2021/1421

Erection of two pairs of semi-detached dwellings (4 no. house in total) and associated works

Land adjacent to 110 New Street, Darfield, Barnsley, S73 9LL

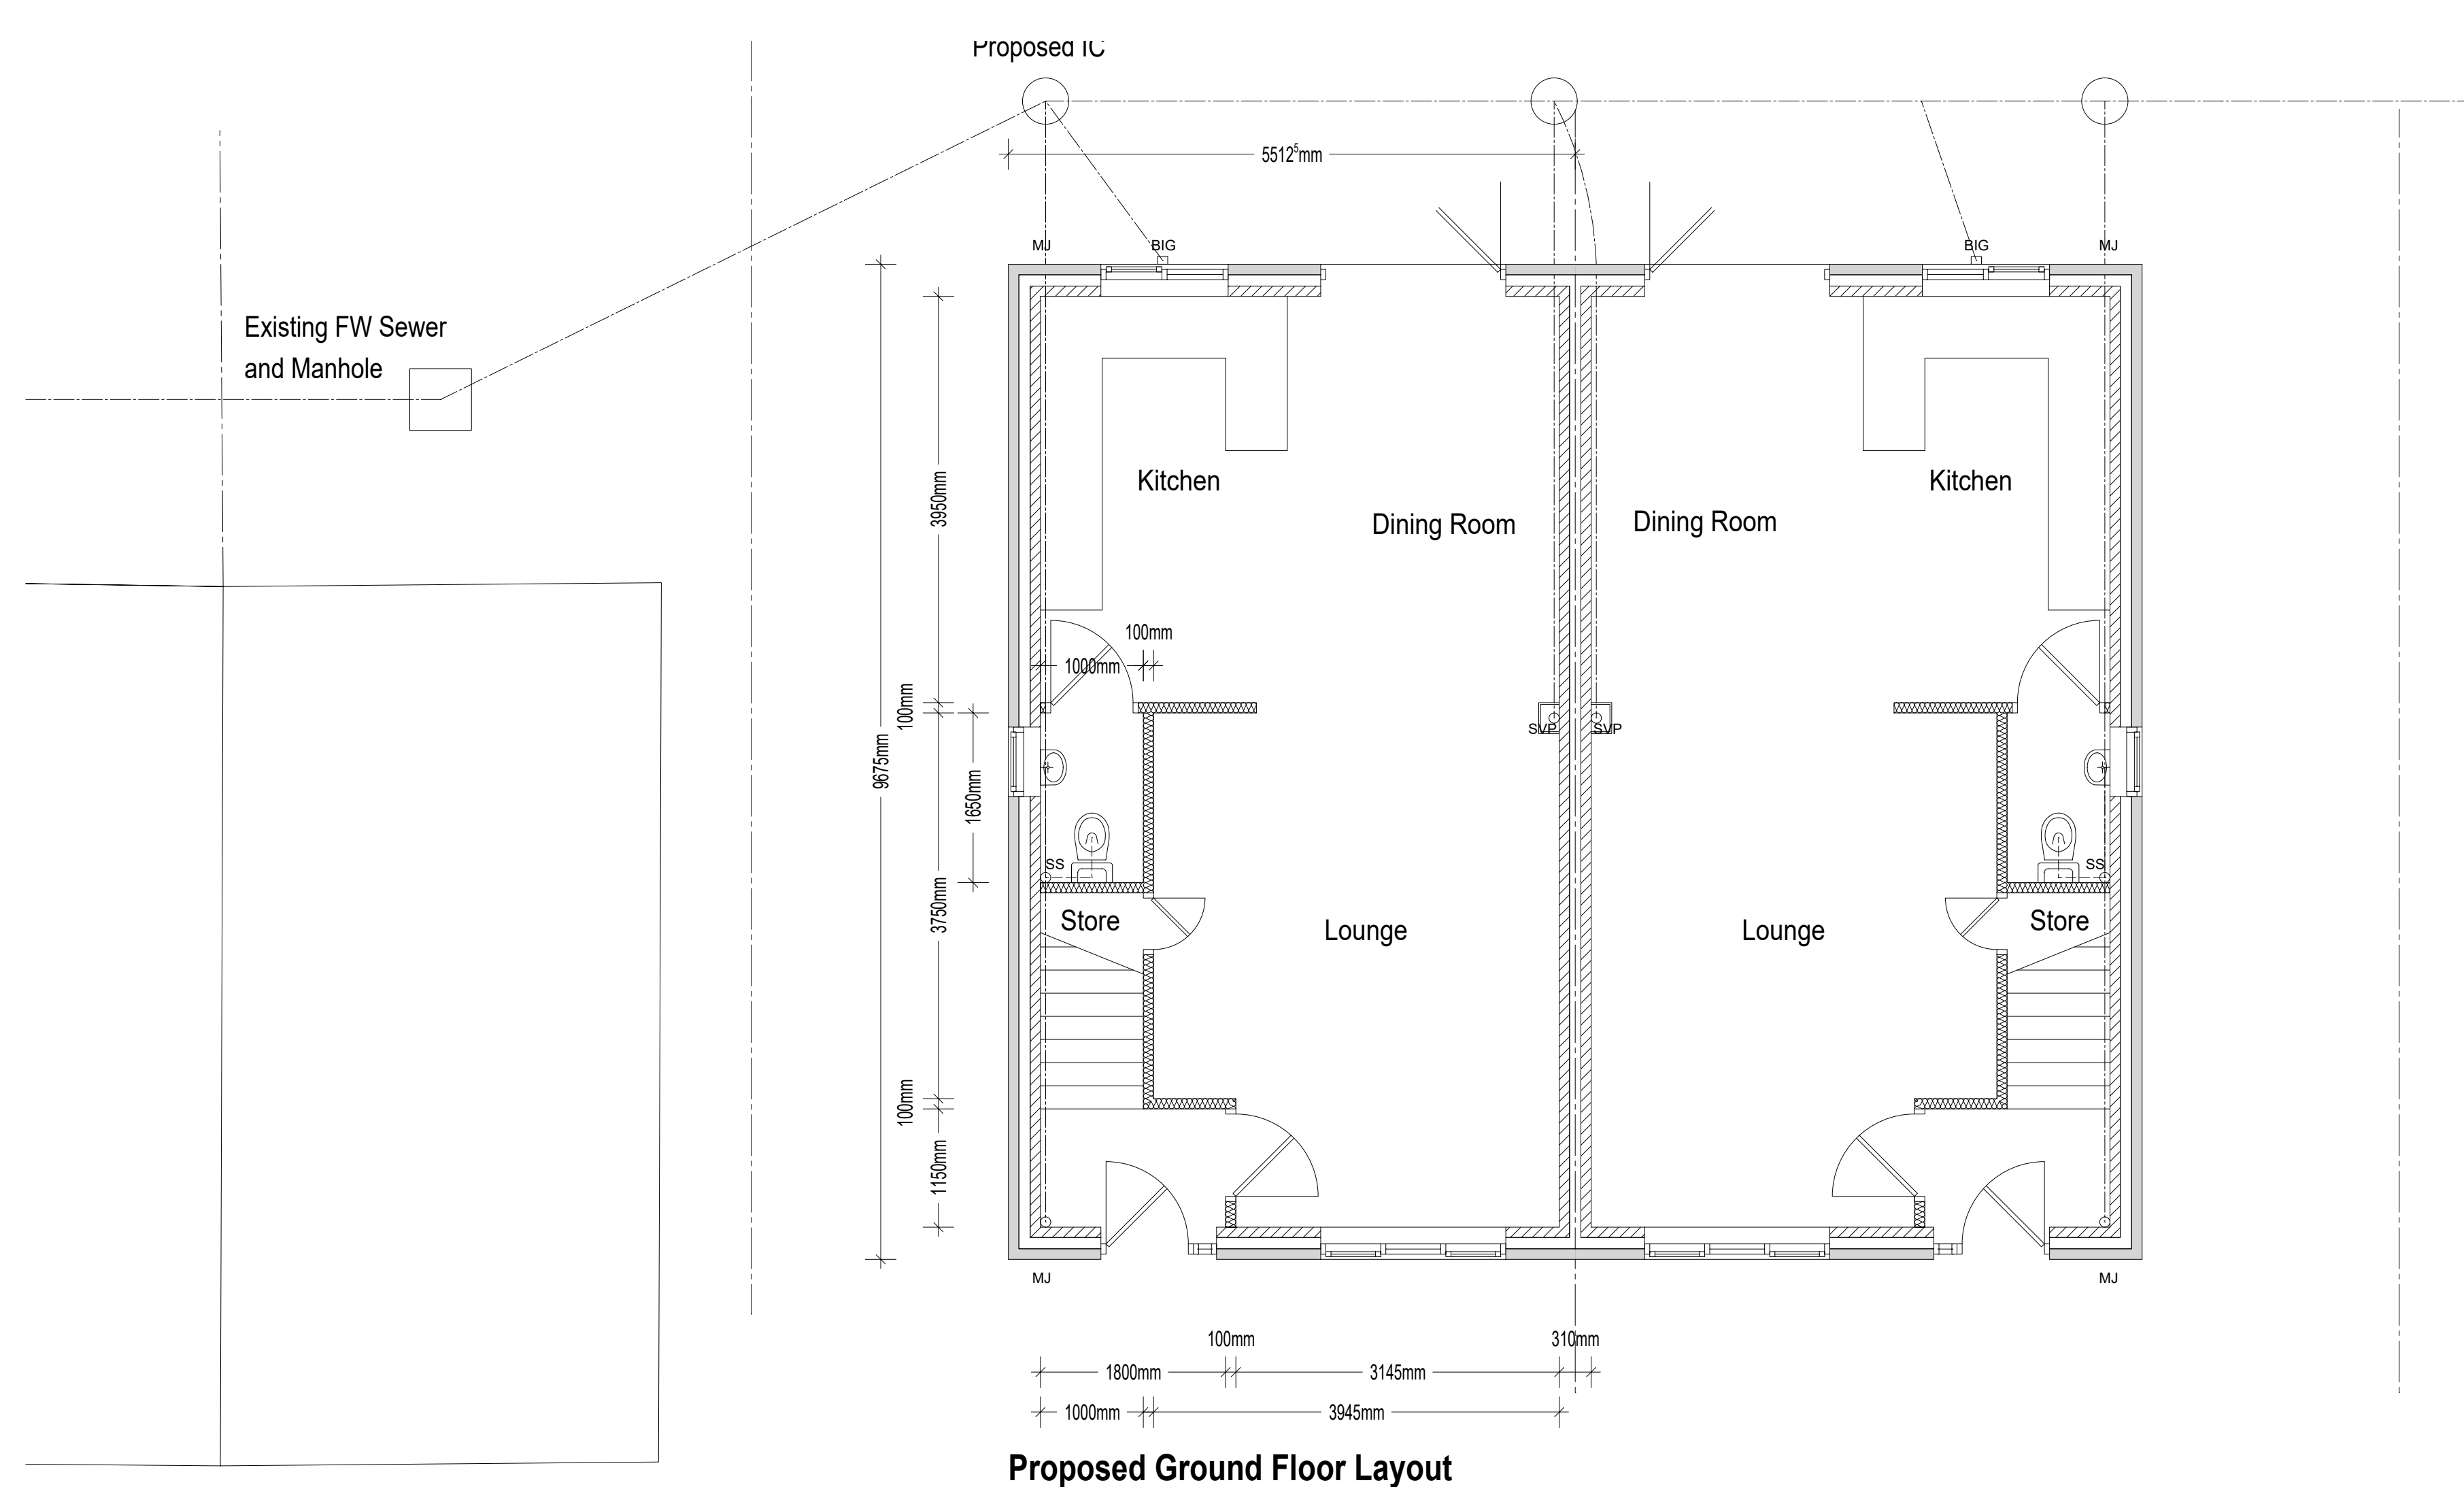
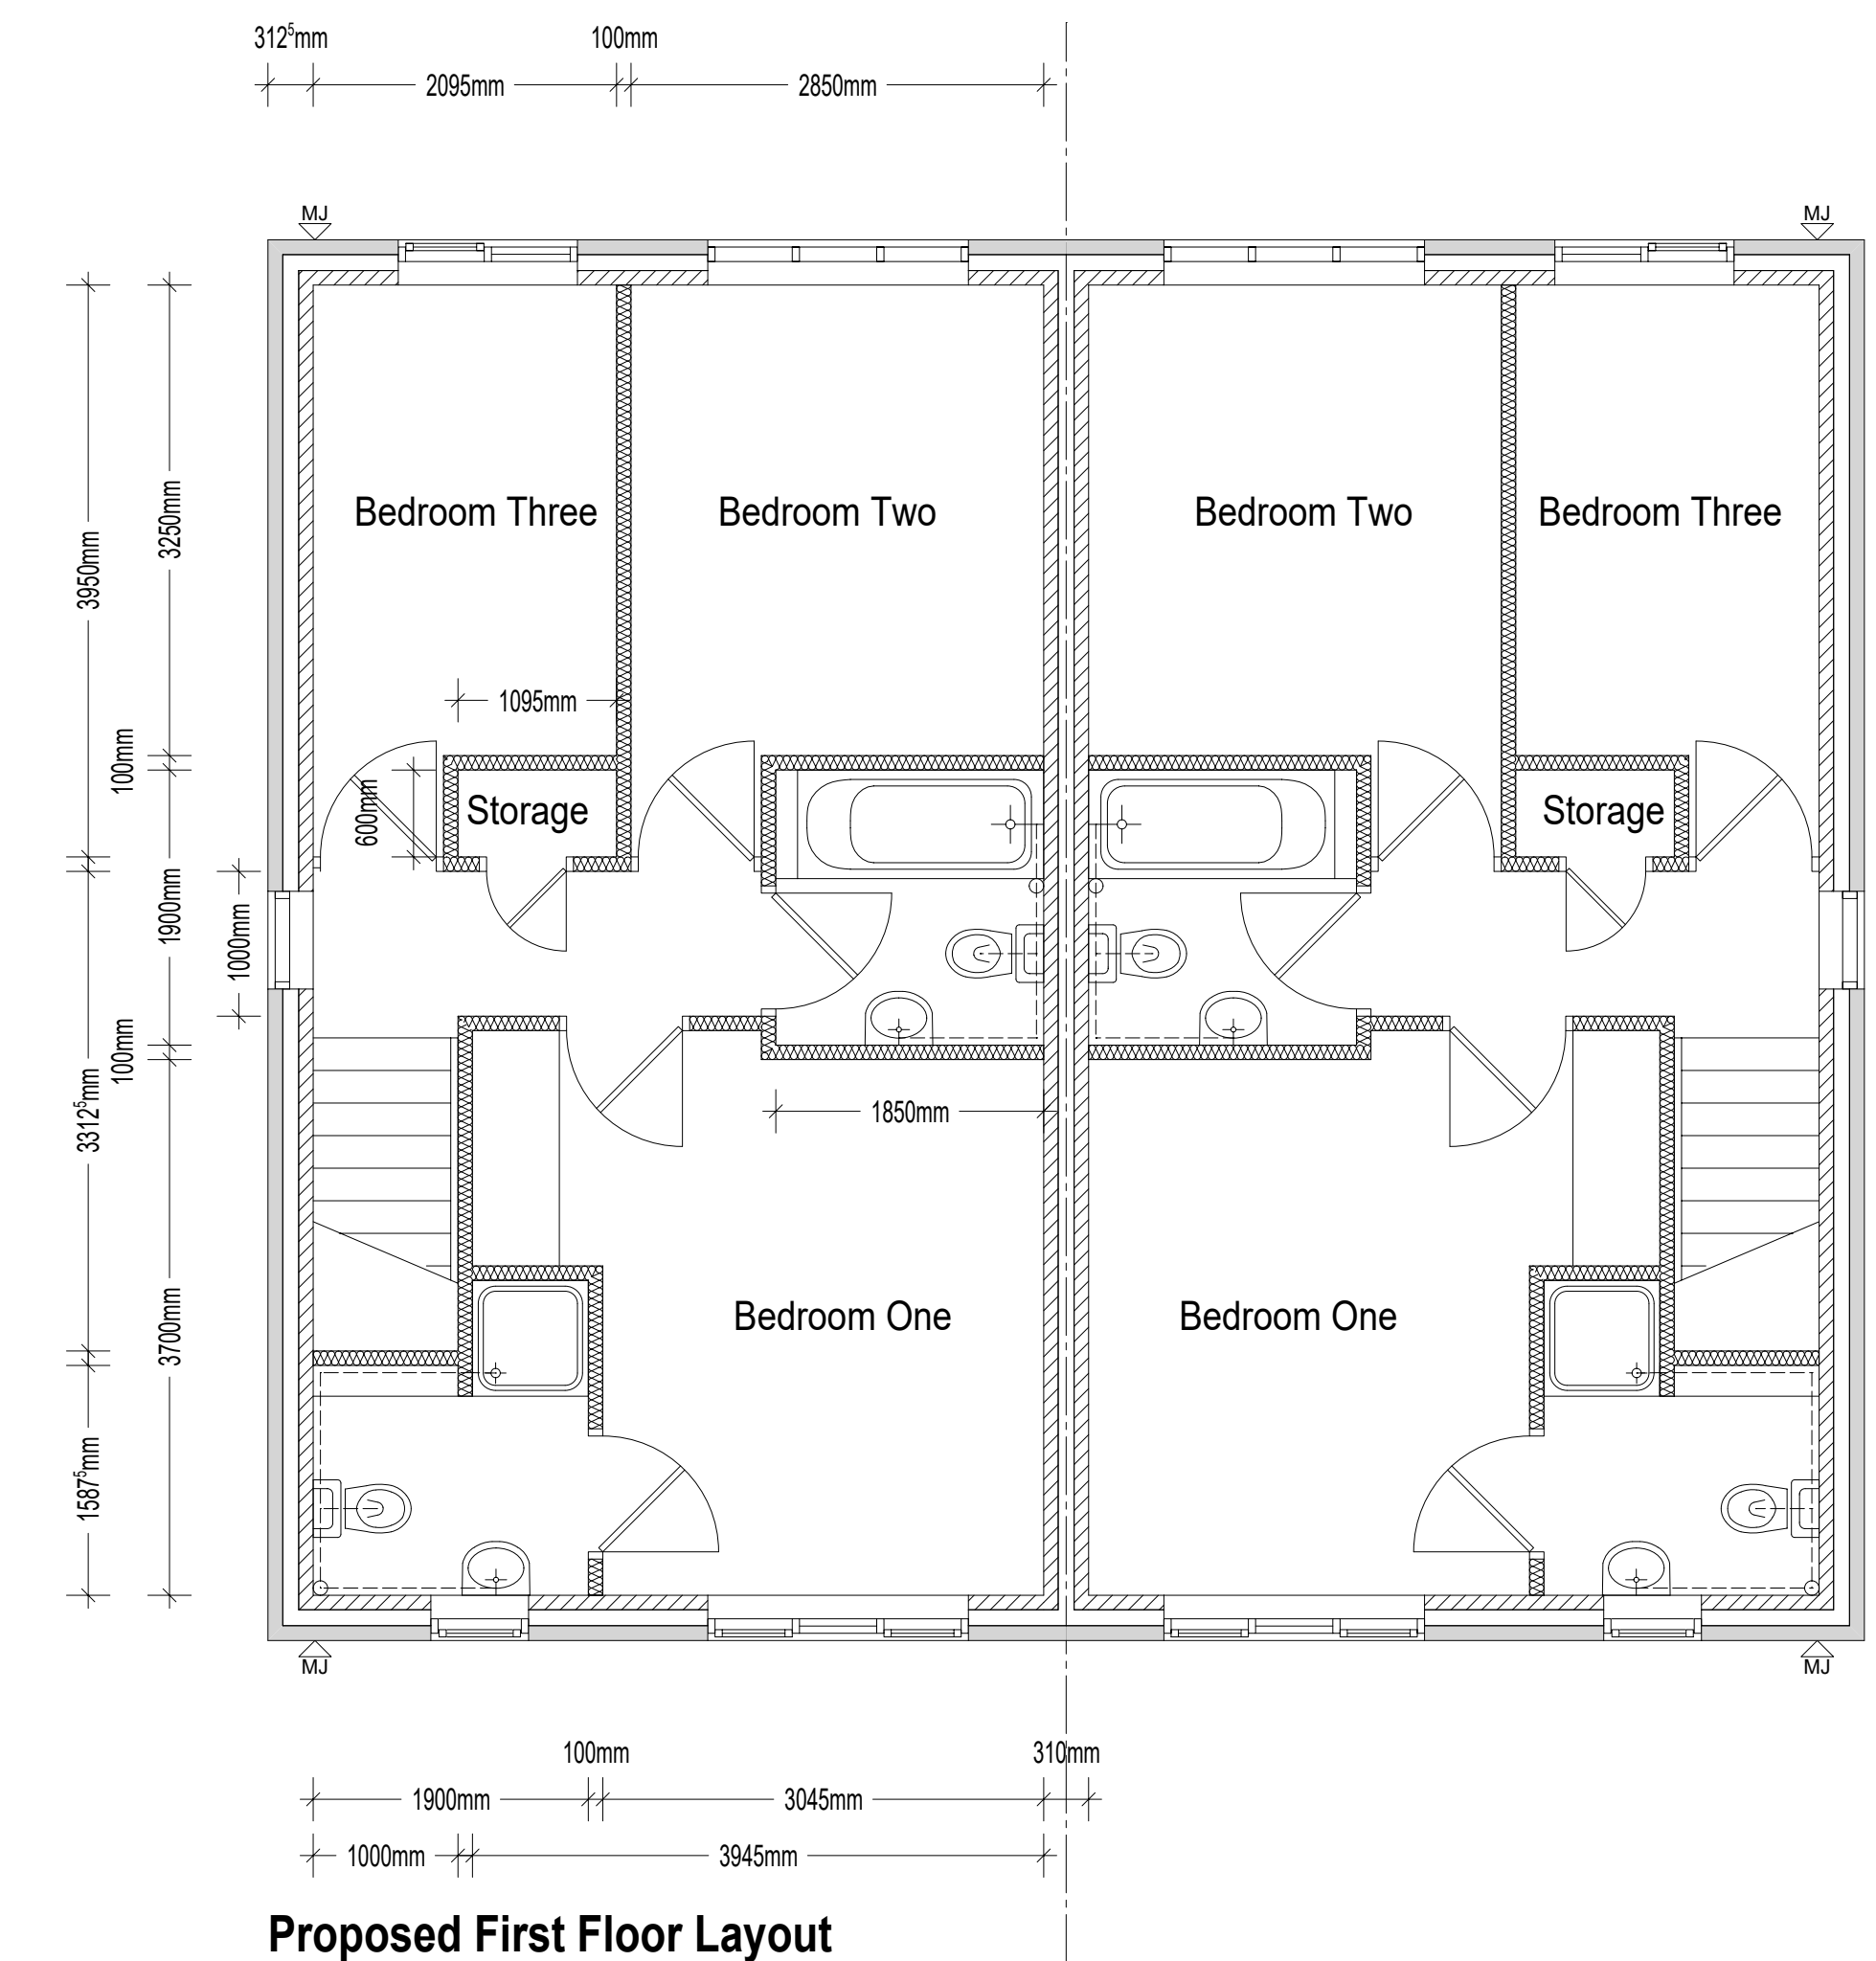
'On the attached plans there is not clear evidence as to how high these properties will be. There are details floor plans with measurements, detailing exact size of each room etc but not clear indication of height. Considering these houses will be a prominent feature on top of a hill, with corresponding views across a wide aspect I believe clarification on the final height of the buildings. The redacted application makes no reference to the colour of the 'reconstituted stone' on the front elevation. Again, given the prominent location these houses will take on a hill overlooking the valley and other houses it may be useful to know which colour these houses will be. The parking areas on both houses don't make it clear how big the parking spaces will be and how many vehicles each will hold. Given the narrow access road to these properties a little clarity on this would be helpful.'

The properties are of a simple design with one house type proposed of a symmetrical design, with small front porch canopies. The proposed dwellings are not as tall as the terrace row adjacent; however, this is acceptable as there is a variety of ridge heights seen along New Road. The proposed plans show a street view so a comparison can be made with the existing terrace row. The proposed dwellings are set back from the highway to allow for a small front garden area and parking areas to the side which is in line with the guidance within the SPD. The proposal put forward is considered to be acceptable in terms of visual amenity in accordance with the Supplementary Planning Document Design of Housing Development and Local Plan Policy D1.

Amended plans have been submitted at the request of the Highways Officer, in order to show 2m x 2m pedestrian visibility splays and the driveways have been increased in size to provide 2 parking spaces per unit in line with the SPD. The Highways Officer has no objections to the proposal from a highway safety perspective. The proposal is in accordance with Policy T4 of the Local Plan.
